**Our Ref: AB/121/11/
Your Ref:**

Please ask for:
Mrs S Honney-Bayes
01903 737500 Ext 37445
29th November 2011

**New dwelling in garden & partial demolition of a single storey building. Amendment to previous approval AB/27/09/
55-57 High Street Arundel**

Proposed First Floor Plan

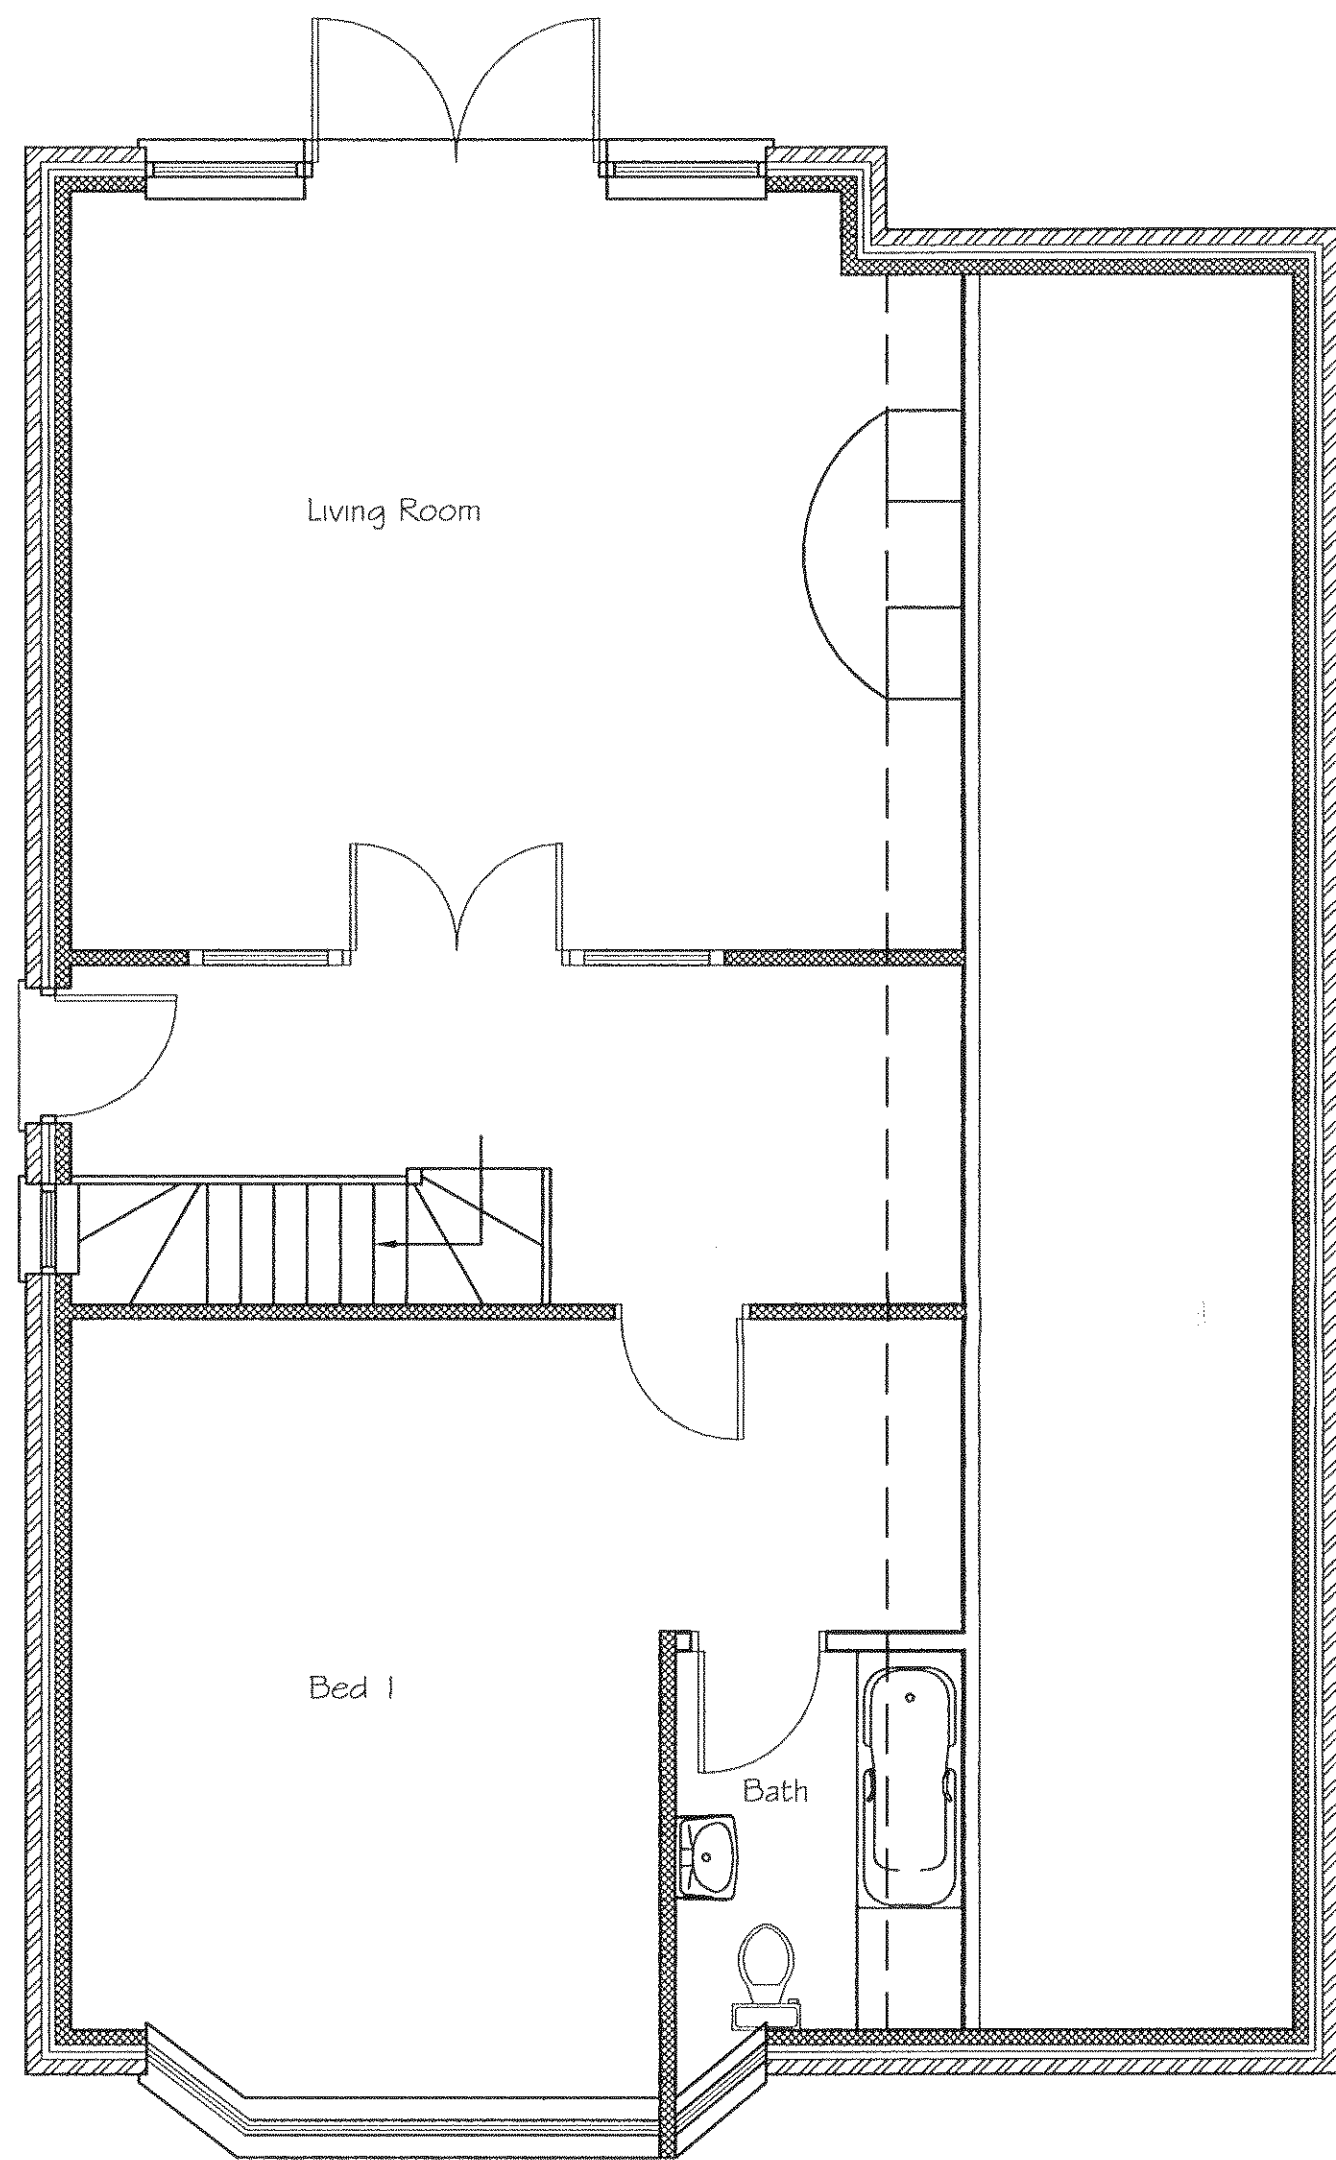
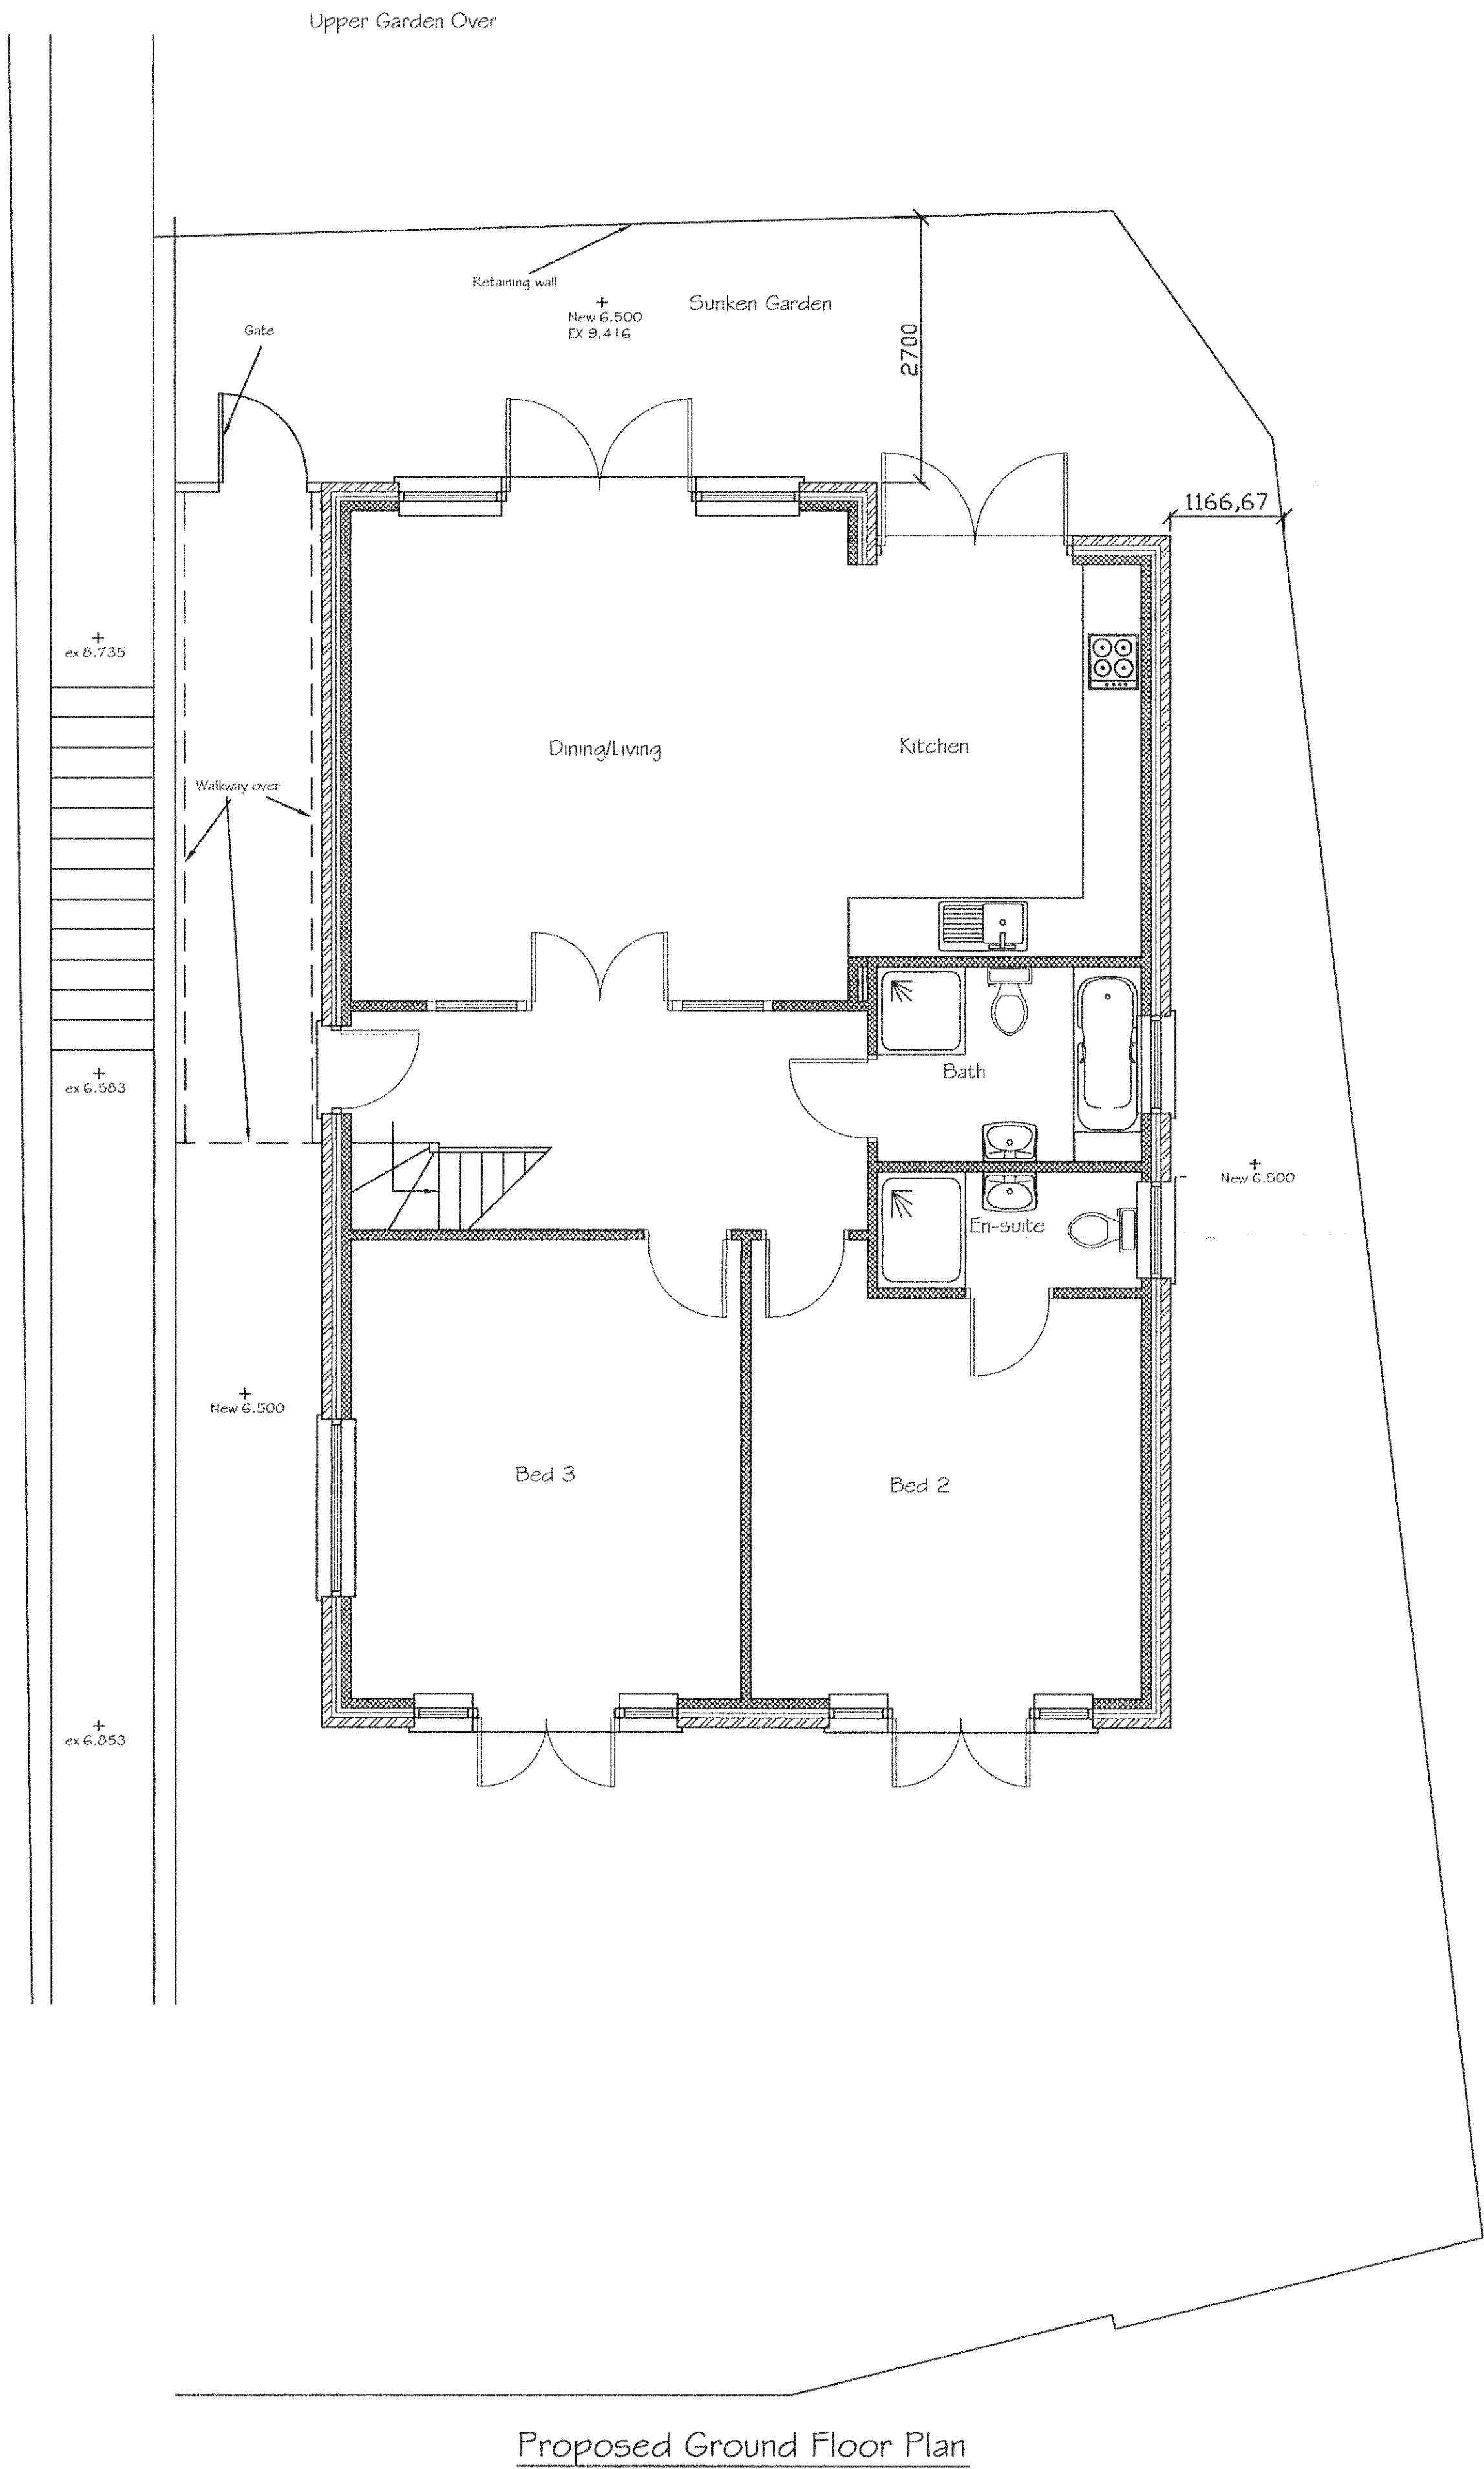
Please provide 1 electronic or 3 paper copies of a revised proposed first floor plan. The window (bedroom 1) does not accord with the elevations. It is shown on the north west and south east elevations, but this is not reflected on the floor plan. Please amend.

55-57 HIGH STREET, Arundel
Block Plan (1500)

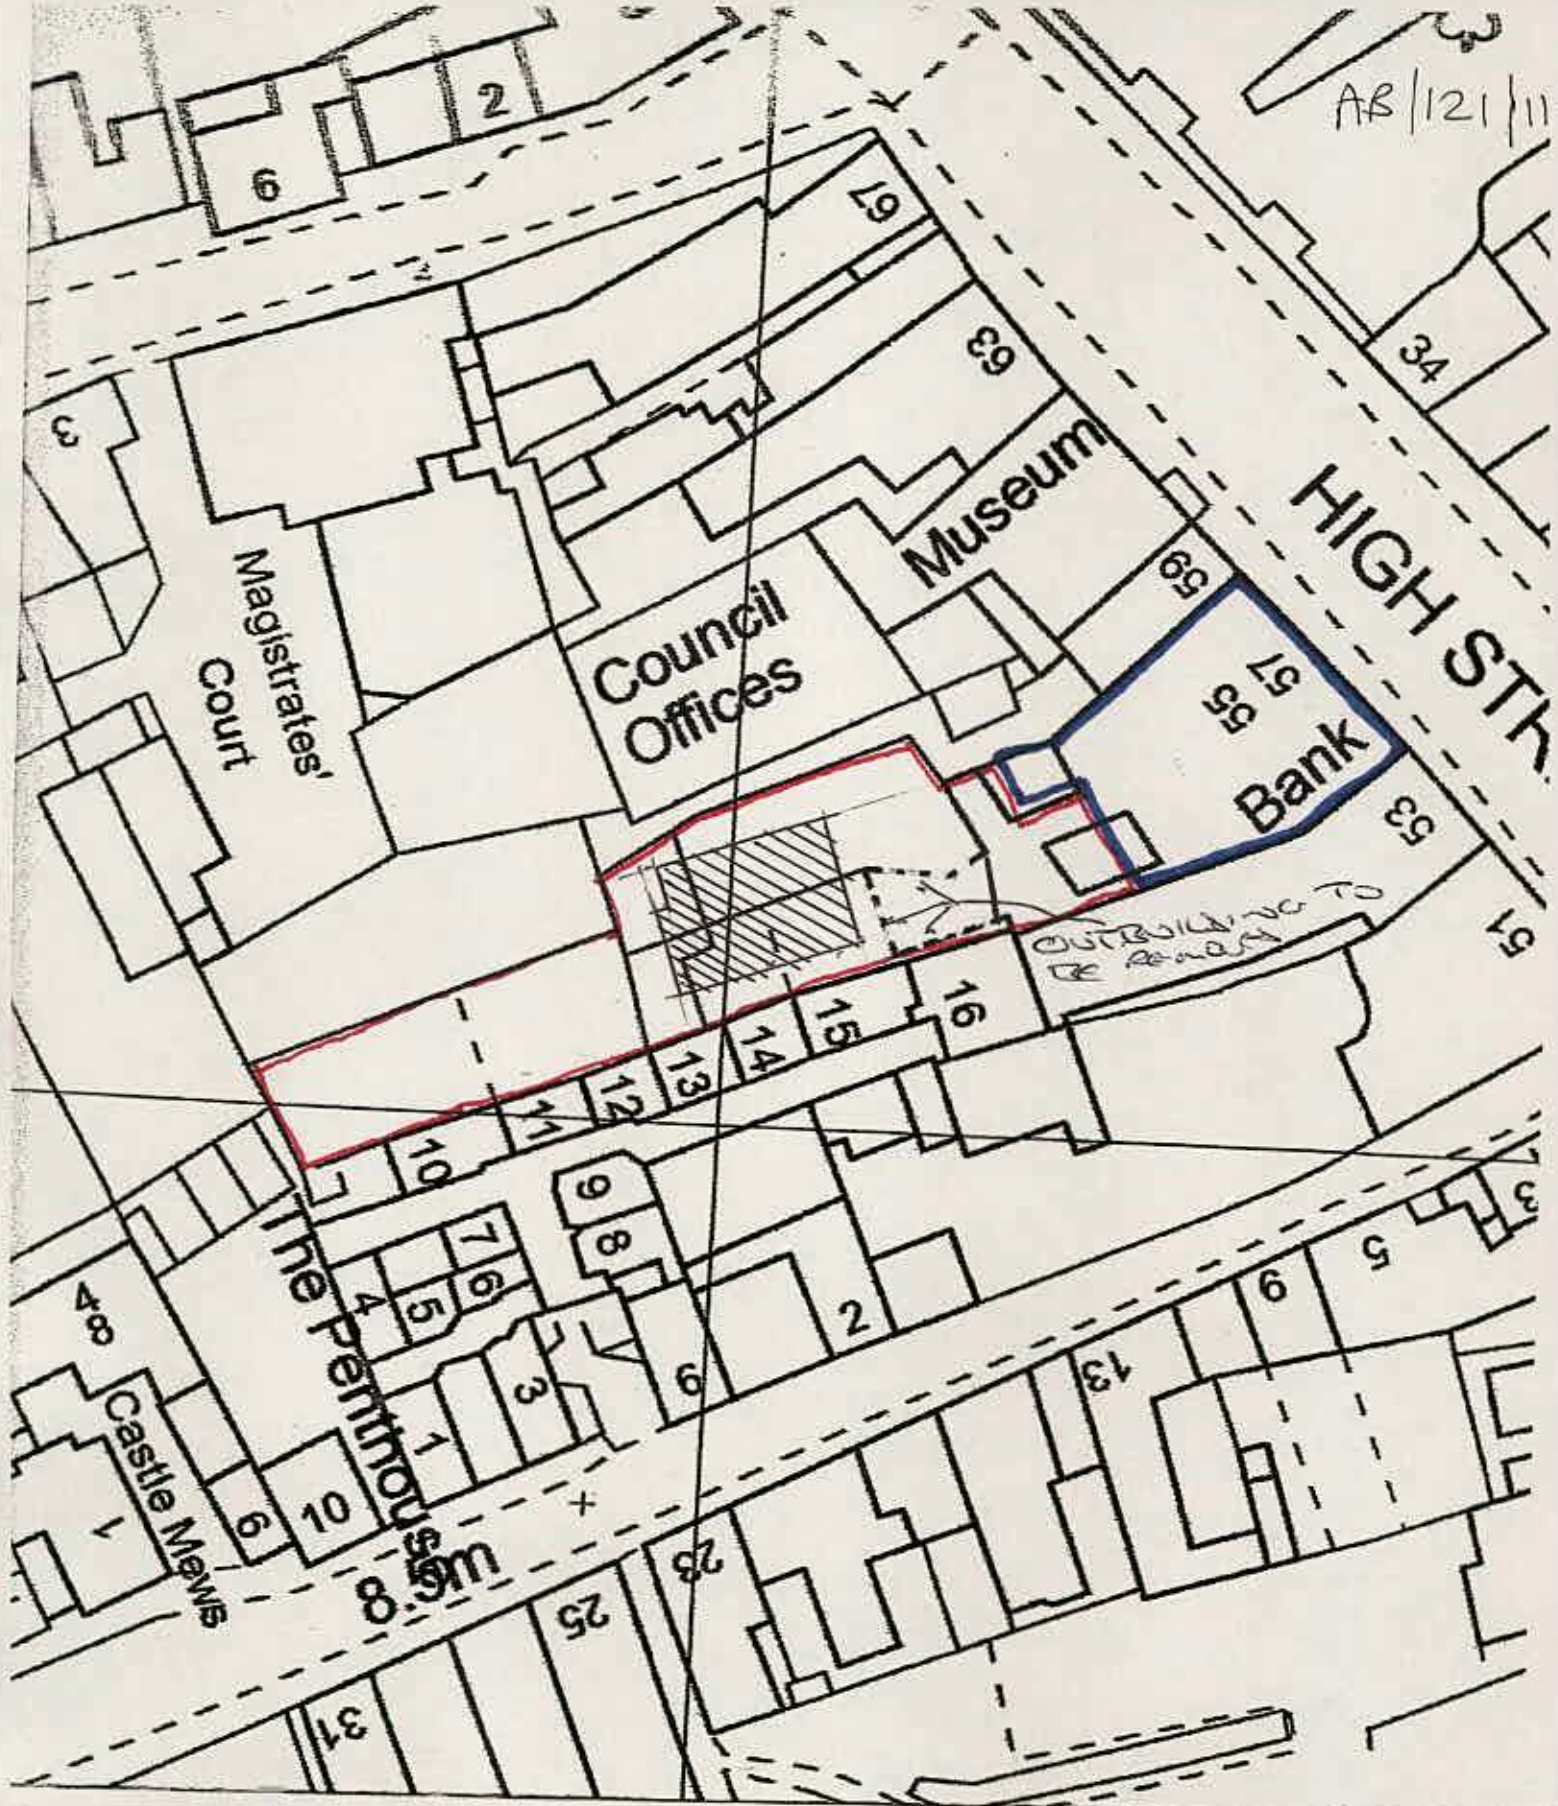
I require 1 electronic or 3 paper copies of a revised block/site plan clearly showing the section of building to be demolished.
